CITY OF ALBUQUERQUE

January 10, 2017

**RE: Independence Square
Grading and Drainage Plan
Engineer's Stamp Date 2-27-16 (File: E17D076A)**

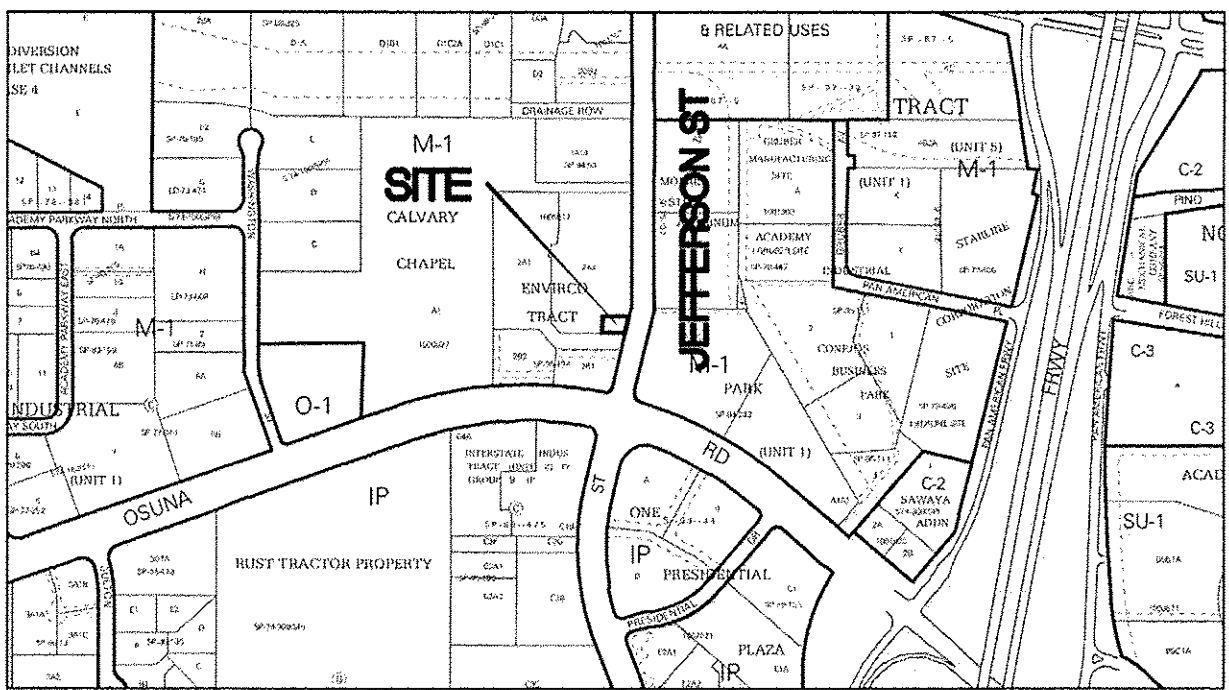
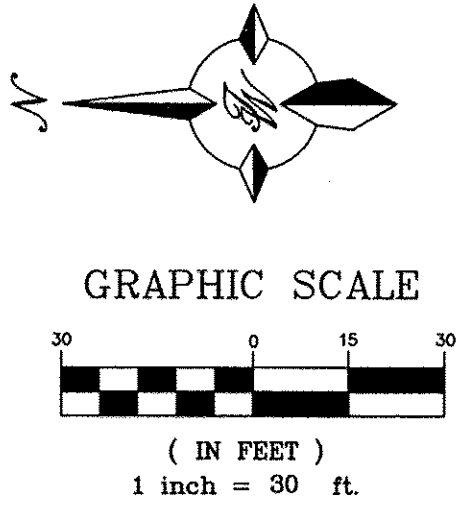
1. Provide appropriate private drainage easements to drain this site through the properties to the south. The drainage report has an arrow for Basin 10 draining south, but nothing for basins 11 and 12 draining through Valero and the referenced drainage plan does not show easements across the sites to the south.

2. Provide additional narrative that discusses the improvements "around" the Starbucks".
3. Proposed spot elevations should be shown for work done on this plan only, unless you wish to certify the grades outside the Starbucks pad in which case it is OK.

4. Provide a build note for the channel through the landscape area.
5. Provide a curb cut at/near the 5138.80 spot elevation to allow water from the drive aisle south of the building to flow into the stormwater quality pond southwest of the building. A channel to the pond bottom would help prevent erosion down the side of the stormwater quality pond.

6. Some curbing along the southerly property line must be removed. Provide permission or modification for the removal of the curbs.
7. Provide details for the trash enclosure to ensure runoff will remain within the enclosure. Included a note that the drain must be connected to a Grease Trap then to the sewer system. Show the location of the Grease Trap and the inverts for the pipe.
